**Bank Street Park Mod 2 (SSD-53386706-Mod-2)
 Response to Submissions**

This letter has been prepared by Architectus Australia Pty Ltd (Architectus) on behalf of Infrastructure NSW (INSW) in response to matters raised by the NSW Department of Planning Housing and Infrastructure (DPHI) in the letter dated 18 December 2026 for the proposed modification to Bank Street Park (SSD-53386706-Mod-2).

DRAWING TITLE
TREE CANOPY COVER

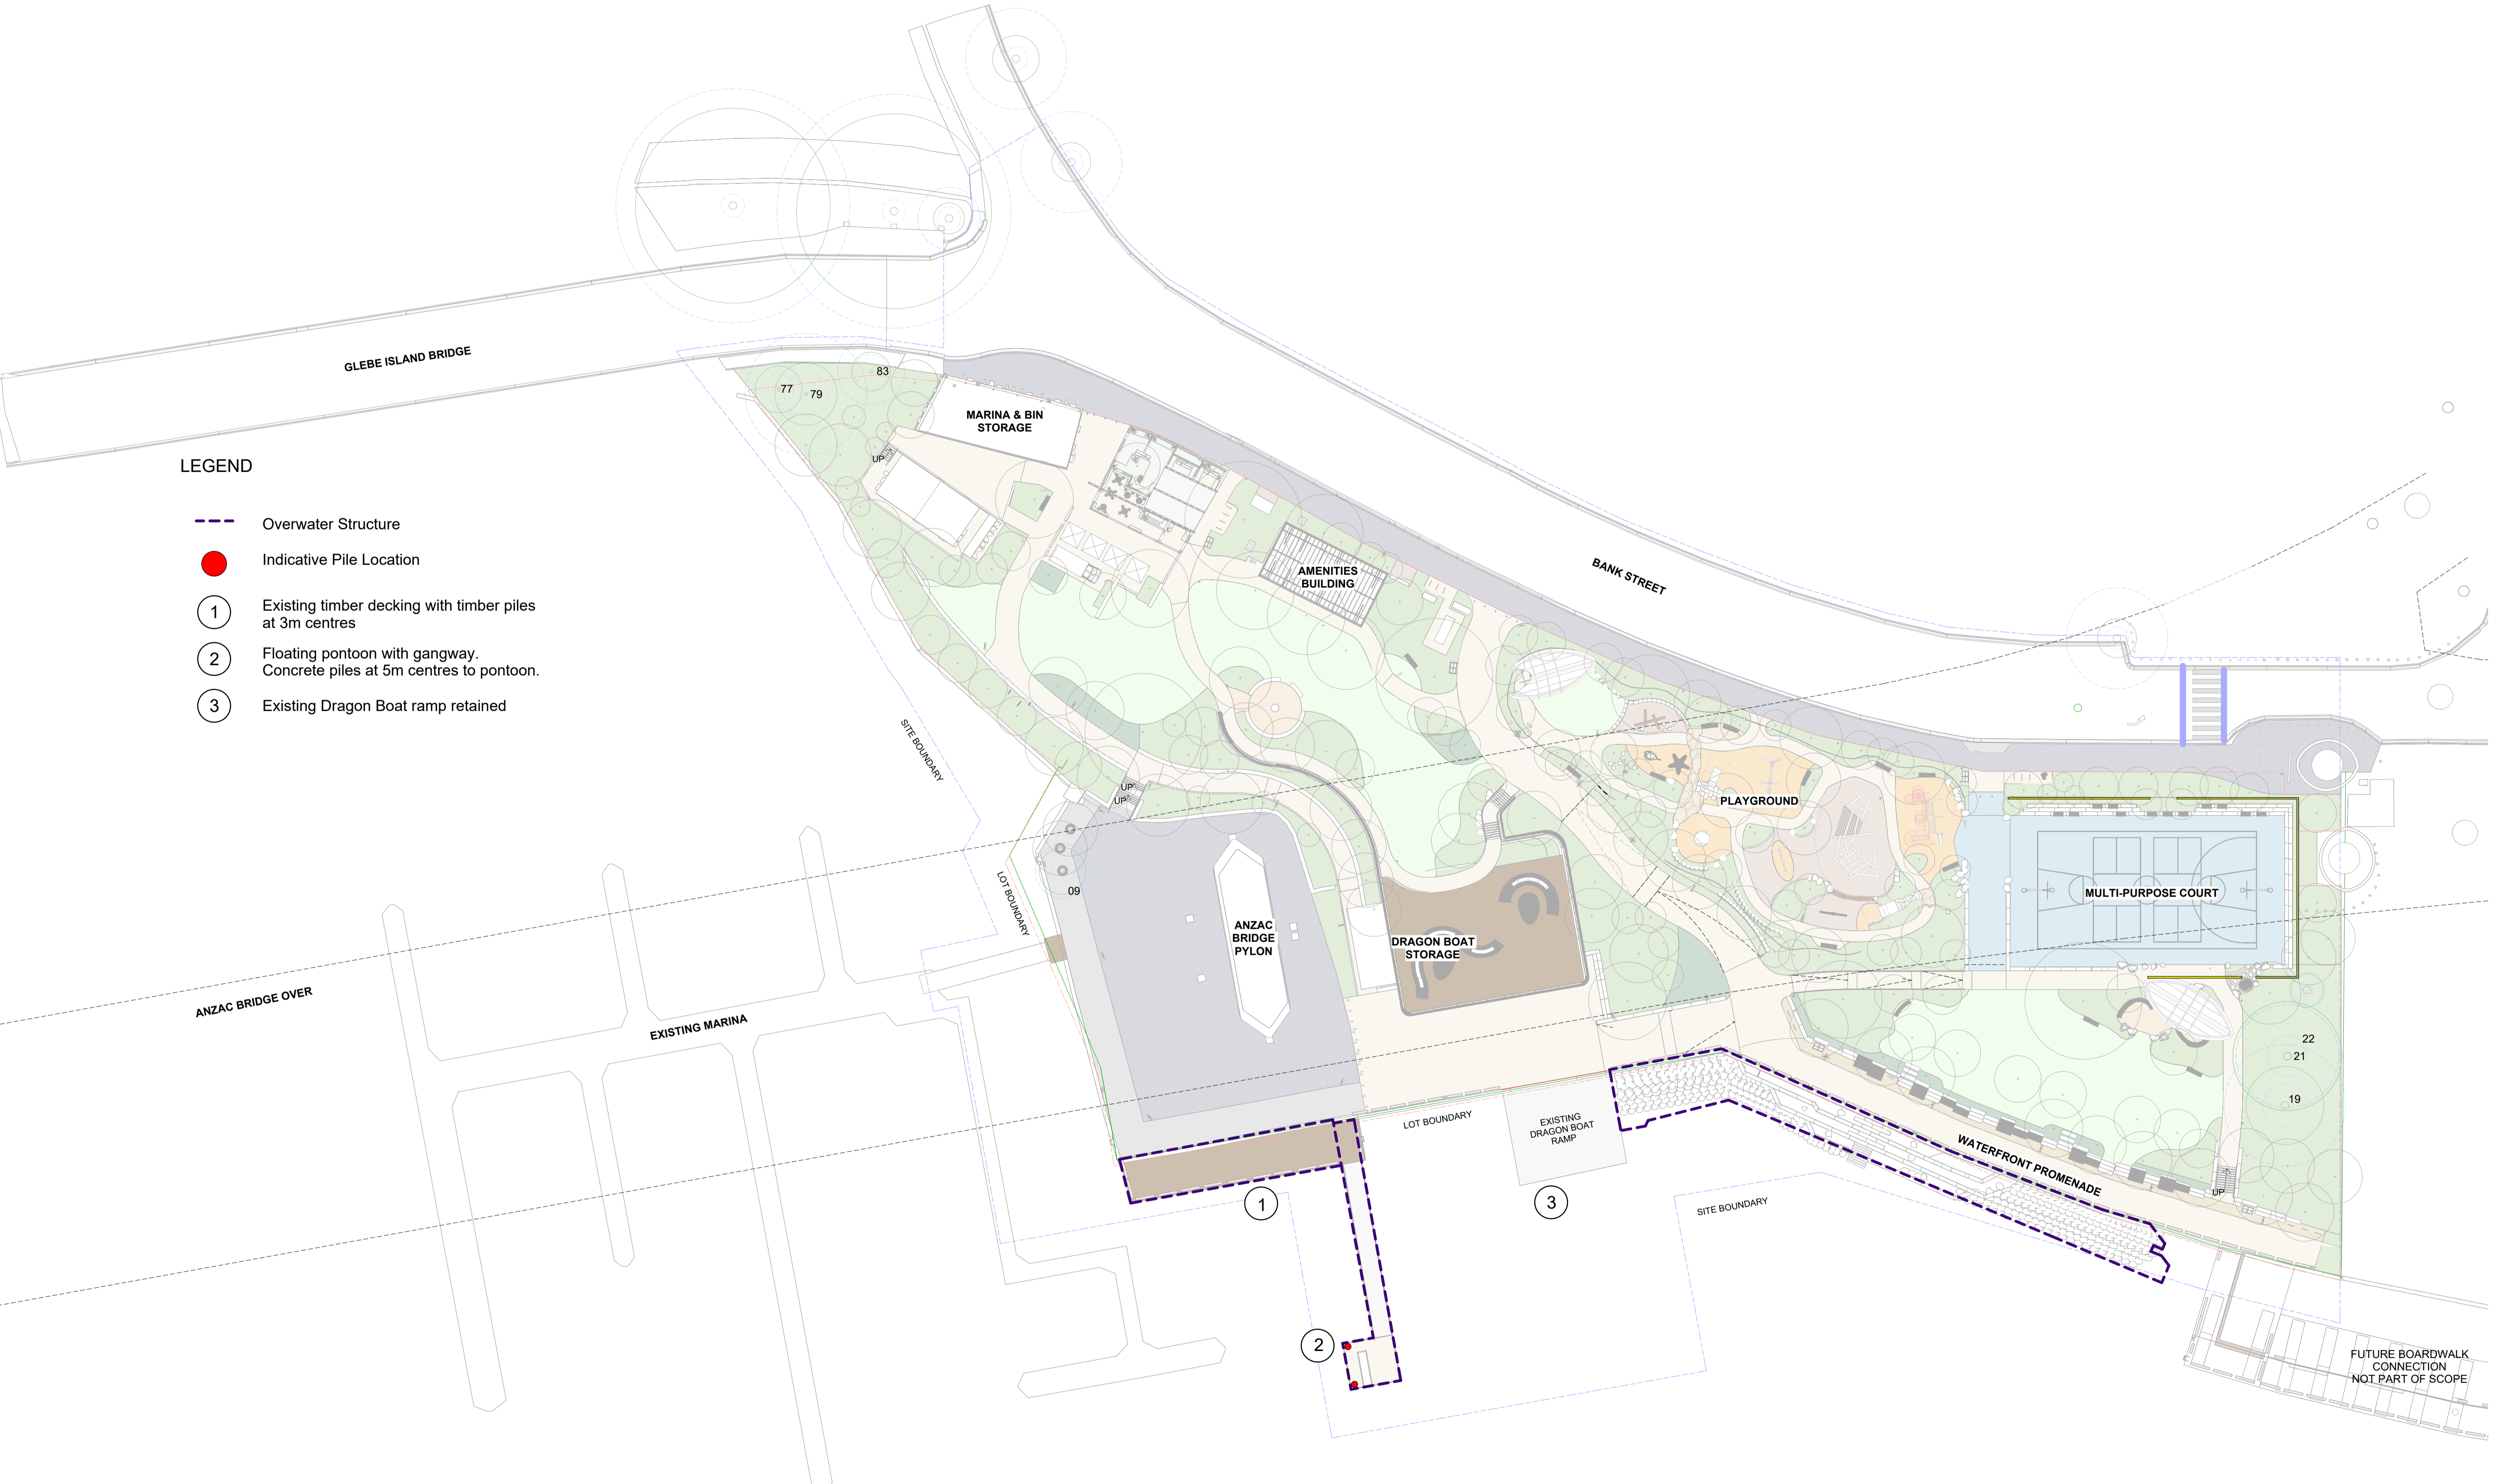
In their submission, Council raised concerns regarding loss of landscaping and tree canopy. DPHI also sought clarification on the number of trees to be removed, noting the amended plans submitted with this RTS include removal of one additional tree (refer Section 2).

The proposed modification (Modification 2) includes a minor reduction in tree canopy from the approved Modification 1, however will maintain same overall tree canopy cover (+11m²) at maturity as approved under the original SSDA approval (SSD-5338670).

This minor reduction over Modification 1 is attributed to trees adjacent the ANZAC bridge pylon that were added within Modification 1, however are now proposed to be removed under Modification 2. Refer **Table 4**.

DRAWING TITLE
TREE RETENTION AND DEMOLITION

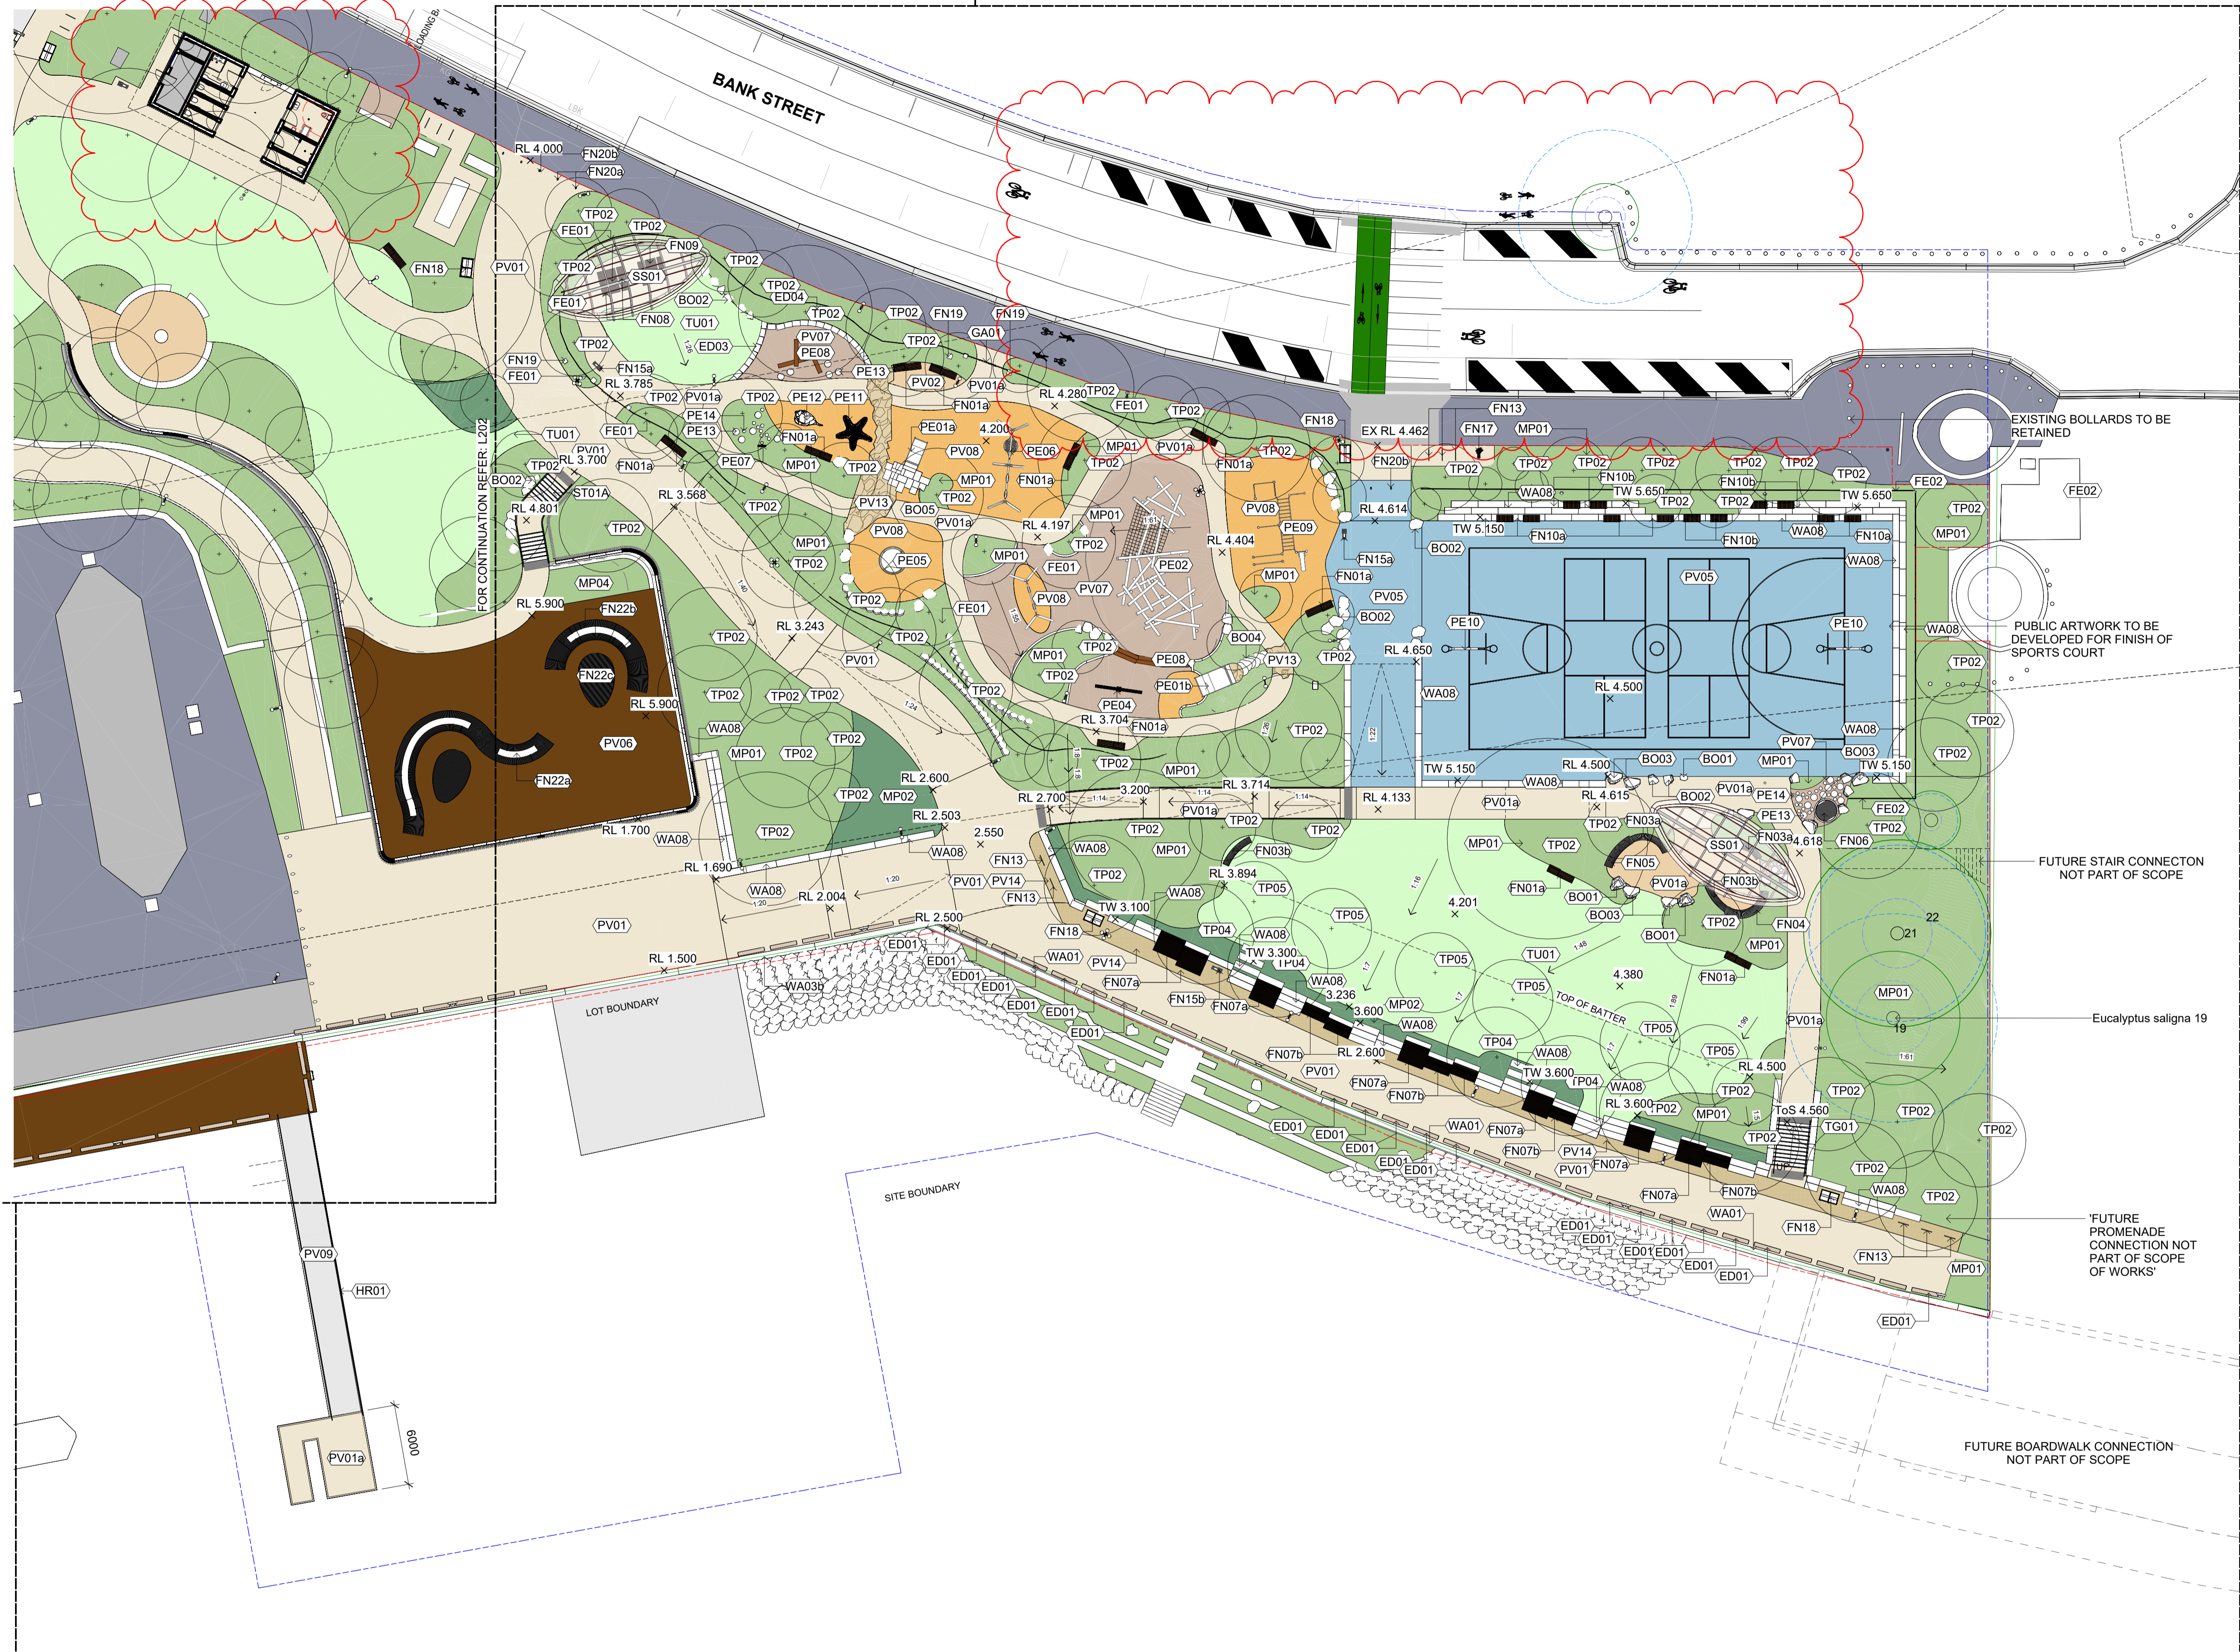
DPHI also requested clarification regarding tree removal and provision at the site. **Table 5** below provides details of trees to be retained, removed and planted as part of this modification.

As detailed in the arborist advice at **Attachment G**, there is both one additional existing tree on site which is to be retained, and one additional tree proposed to be removed by the proposed modification.

The subject modification also includes removal of one additional tree (Tree 22), a *Eucalyptus Saligna* (Sydney Glue Gum). Although previously identified as being in good health and proposed for retention, unrelated to the Bank Street Park development, this tree has been used to demonstrate traditional bark removal techniques (scarring), resulting trunk wounds that have reduced its Useful Life Expectancy (ULE) and is therefore proposed for removal.

In addition to the above, it is noted there is an additional dead tree located to the north of the site near 1-3 Bank Street that is shown for removal on the plans. This tree is unnumbered, as dead trees are not ordinarily included in tree removal calculations. This tree was not included in previous calculations, however if included, would increase the number of trees to be removed in **Table 5** by one.
